Ribble Valley Borough Council
Housing & Development Control

Your ref: 3/2023/0384
Our ref: D3.2023.0384
Date: 10th August 2023

Application no: **3/2023/0384**

Proposal: **Proposed new 4 bedroom dwelling and creation of new access on land to the side of 3 Grindleton View.**

Date: 09/05/2023	Drawn by: JHolden
Scale: 1:100 @ A1	Sheet: 004
Client: Mr & Mrs Bradley	Revision: -

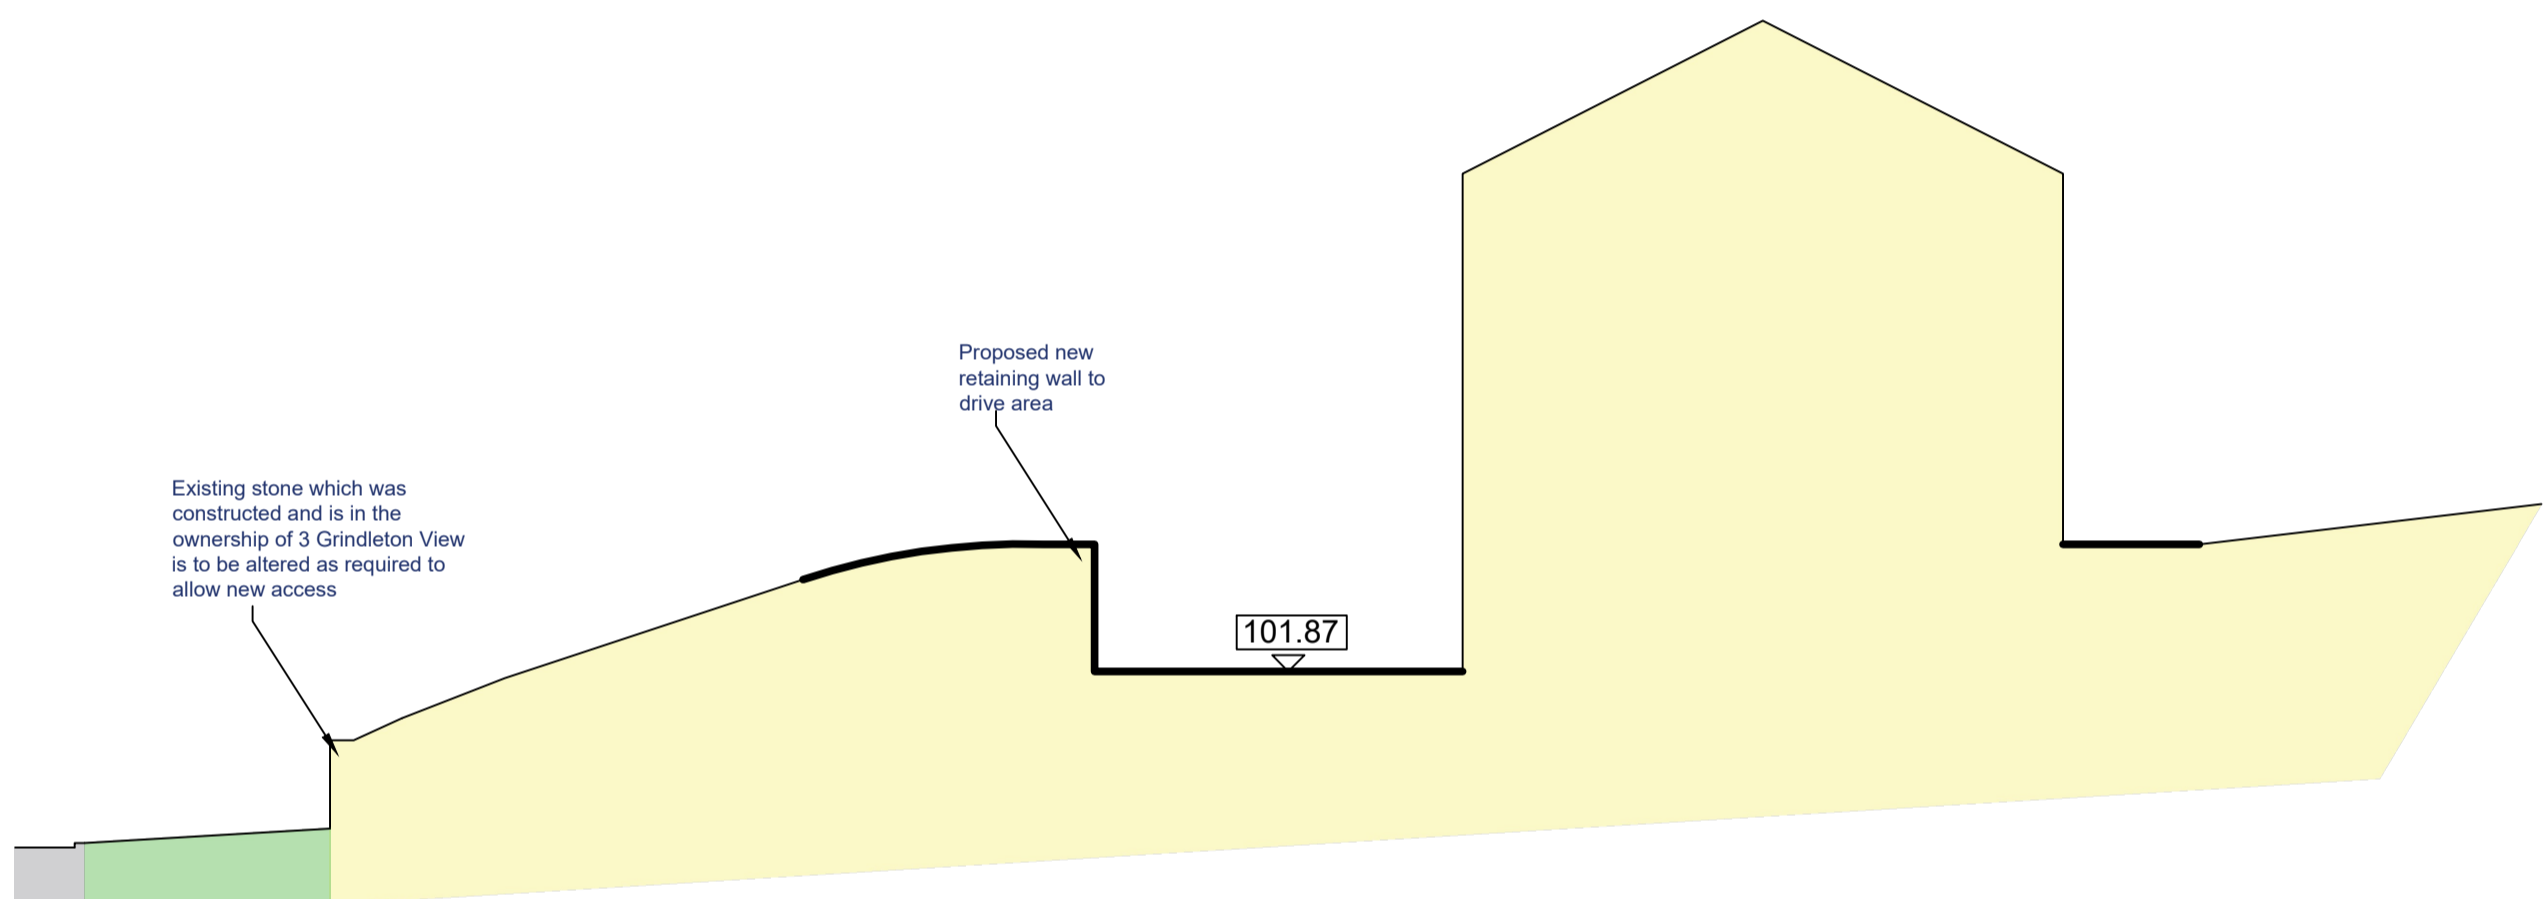
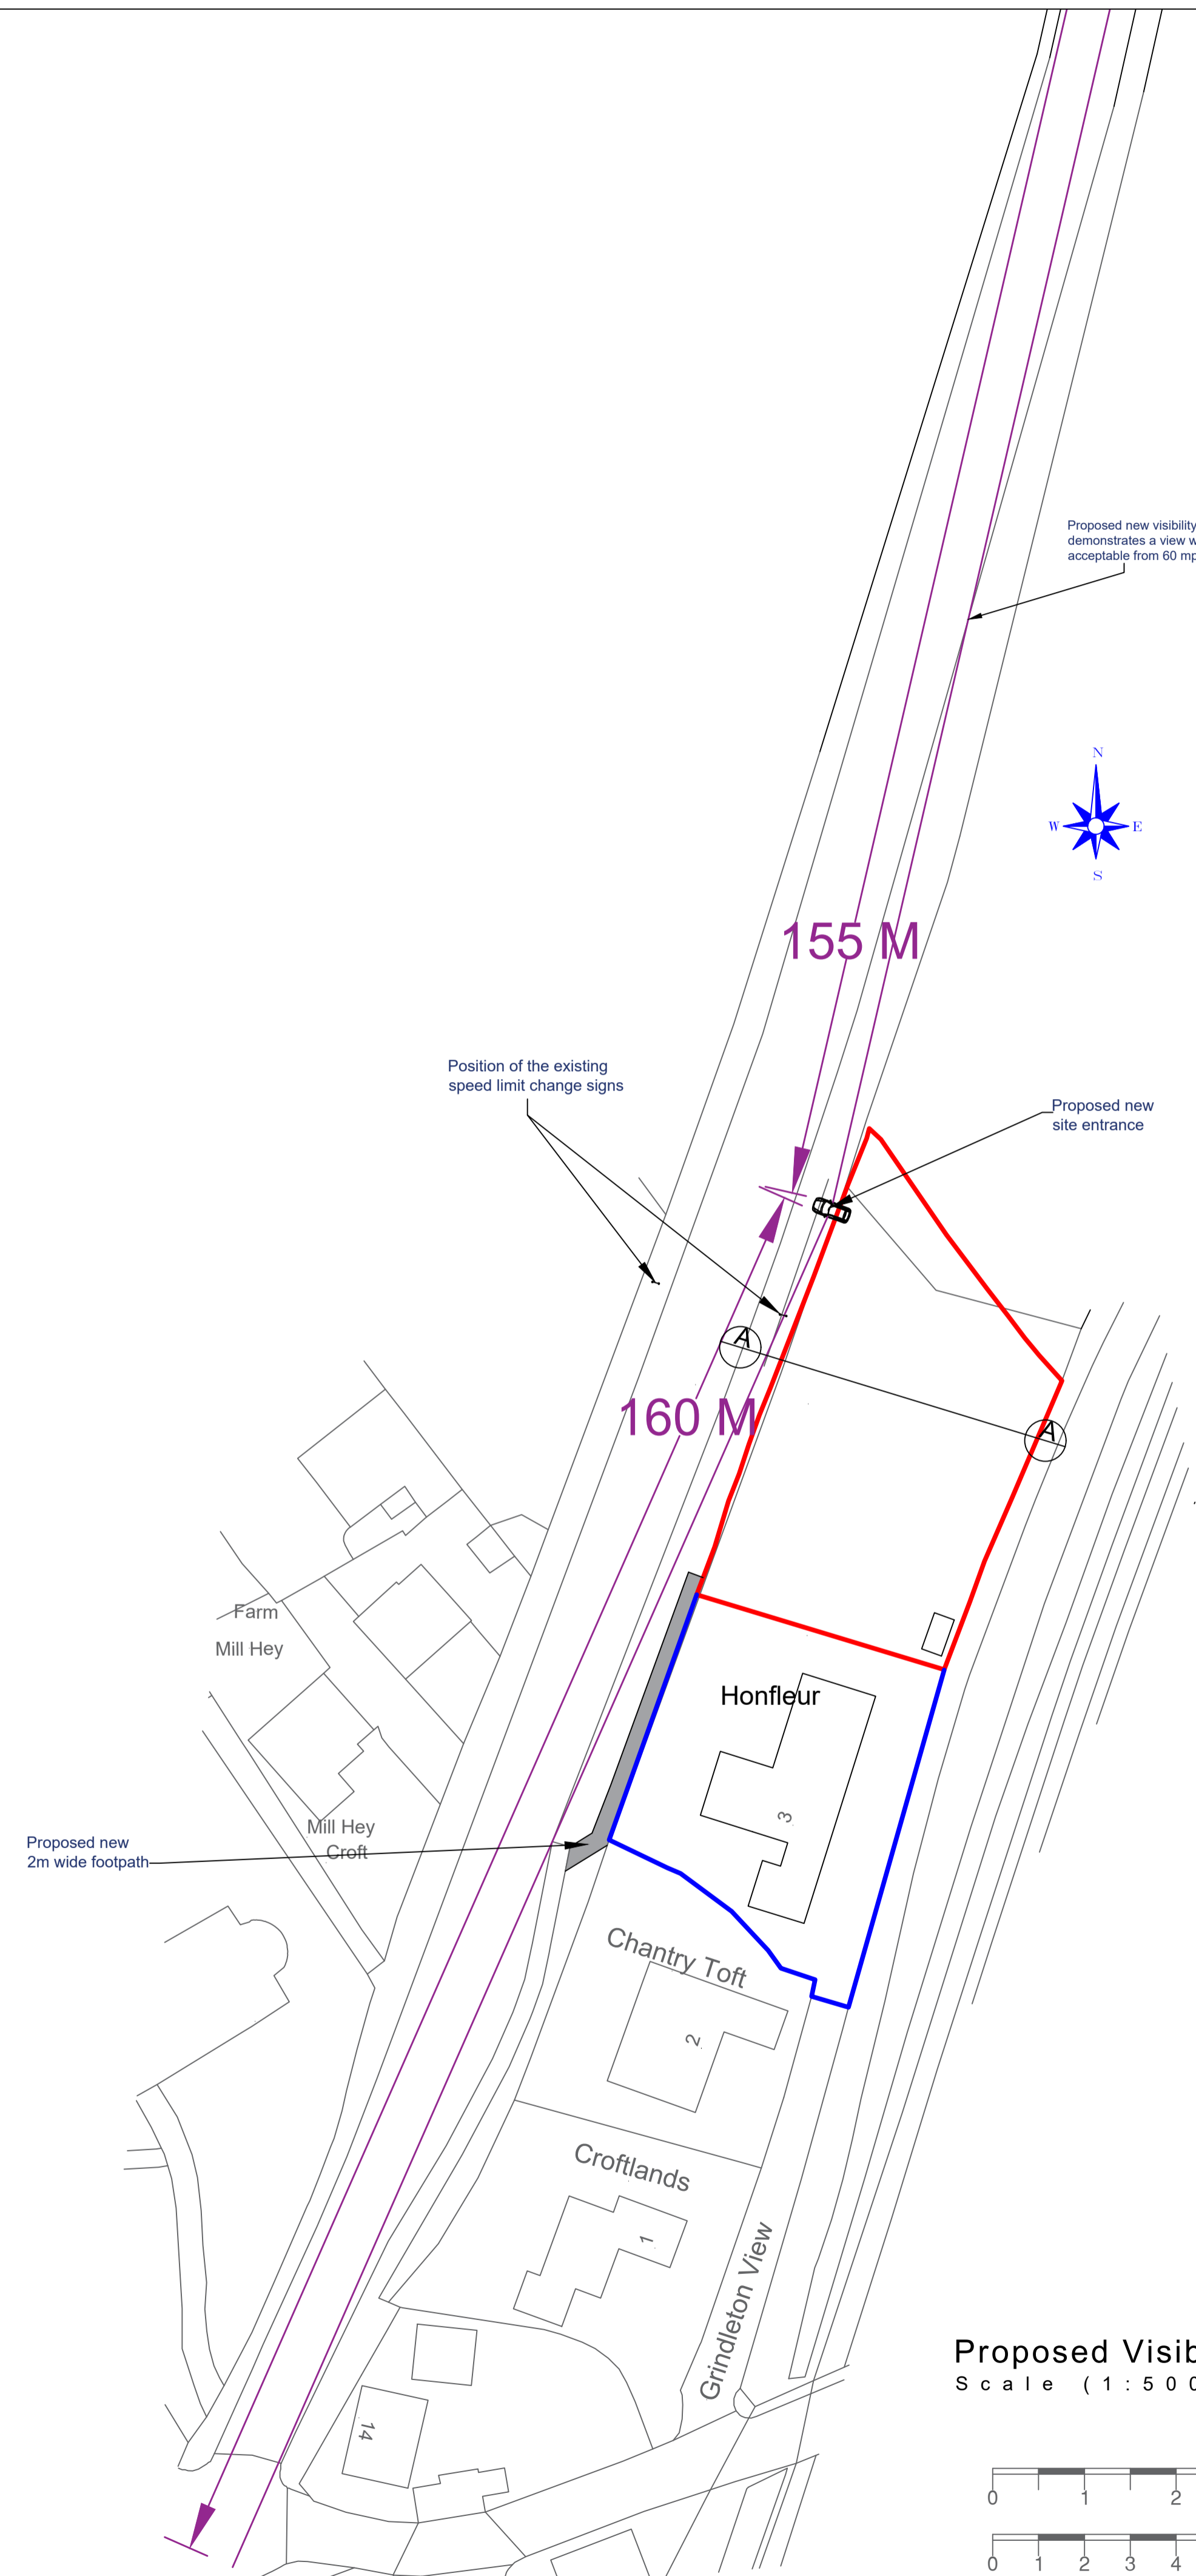
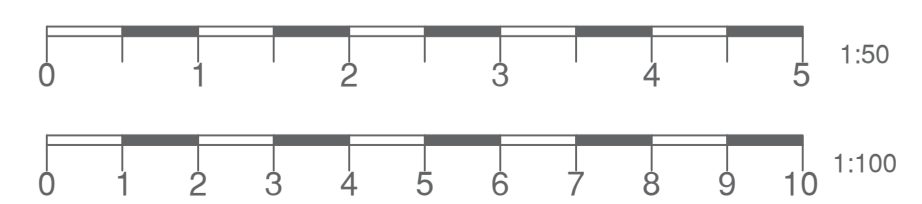
However, due to the site being in between two speeds limits, as mentioned above, the LHA will request that a traffic survey is conducted to determine the 85th percentile speeds within the vicinity of the site, which will enable the LHA to determine the minimum requirement for the visibility splays.

The LHA are also concerned regarding the gradient at the site. The LHA require site section drawings of the access with the site being extremely steep. The LHA remind the Agent that the LHA require the gradient to be no steeper than 1 in 10 and the gradient should be relatively flat across the highway verge. Therefore, the LHA require construction details as to how this can be achieved with the gradient being close to 1 in 1 in places.
